KITTITAS COUNTY

MEMORANDUM

SUBJECT: Godzilla Short Plat SP-11-00014

SHEET 1 OF 3

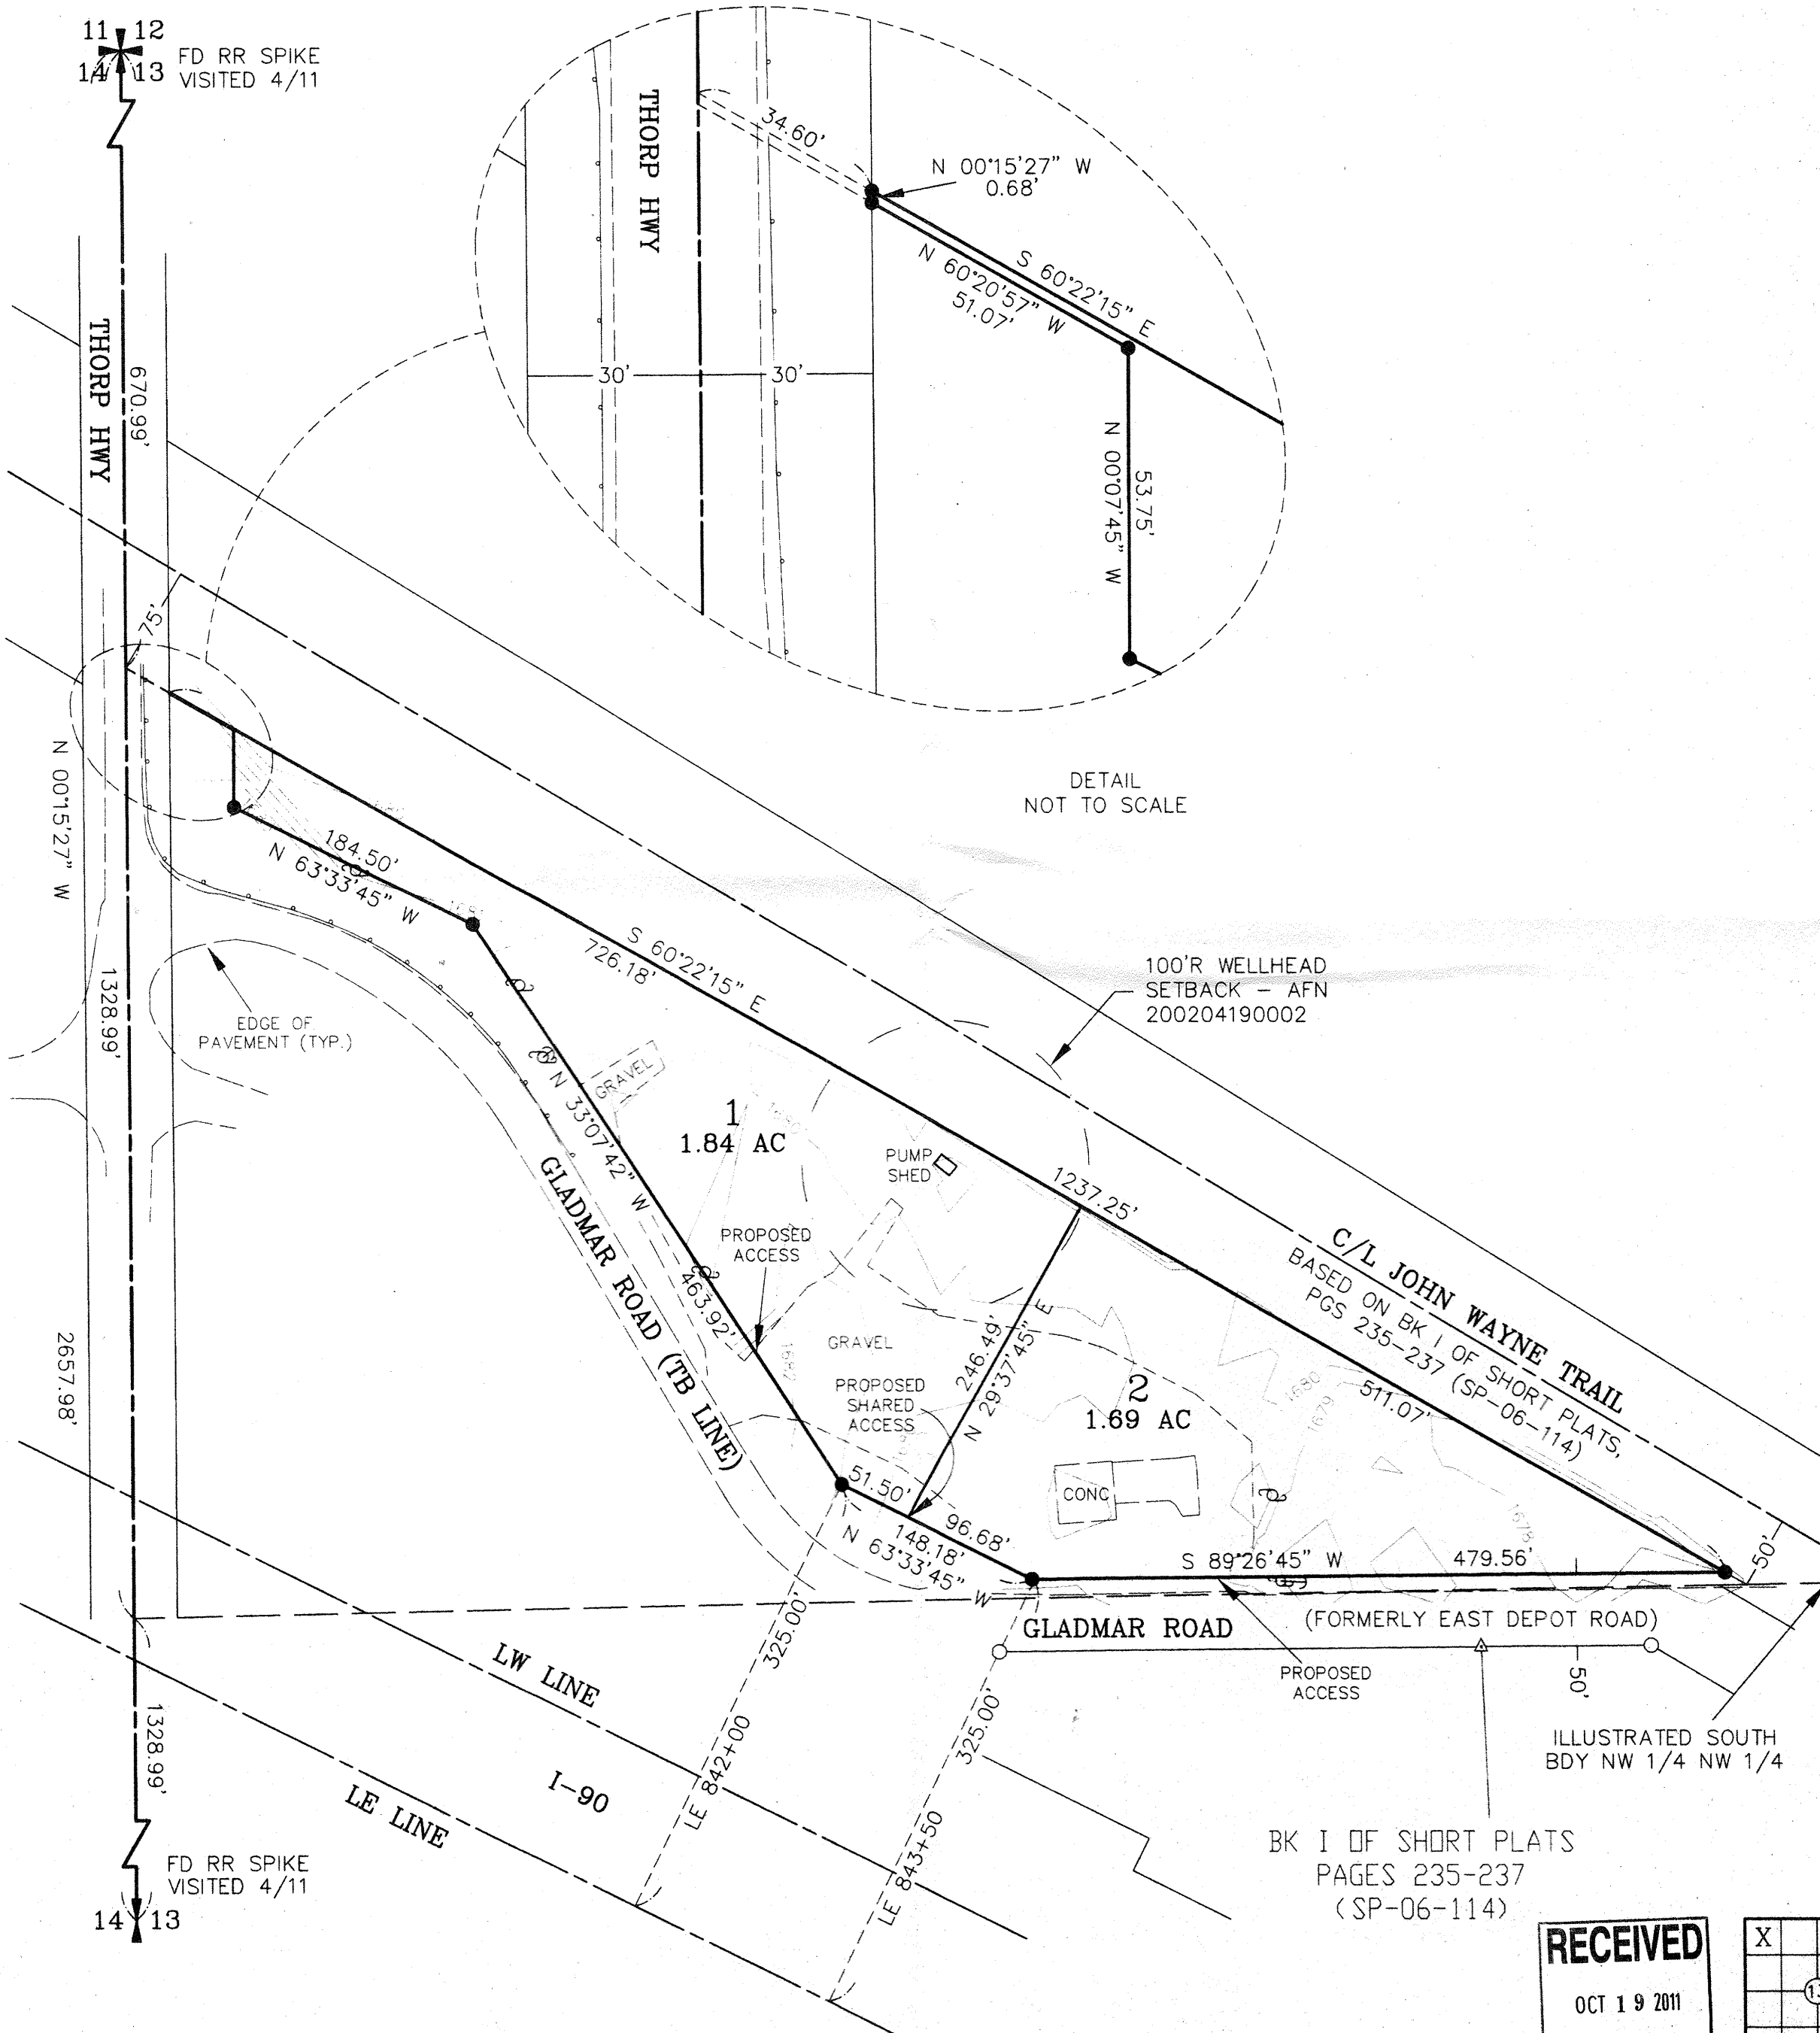
1. Access: Each parcel is allowed one access to Gladmar Road, provided the access location meets sight distance requirements. An additional shared access may be allowed if the location meets sight distance requirements and is allowed by the County Engineer. Currently, the proposed shared access location does not meet these requirements. Any existing accesses will need to be removed prior to use of any new access.
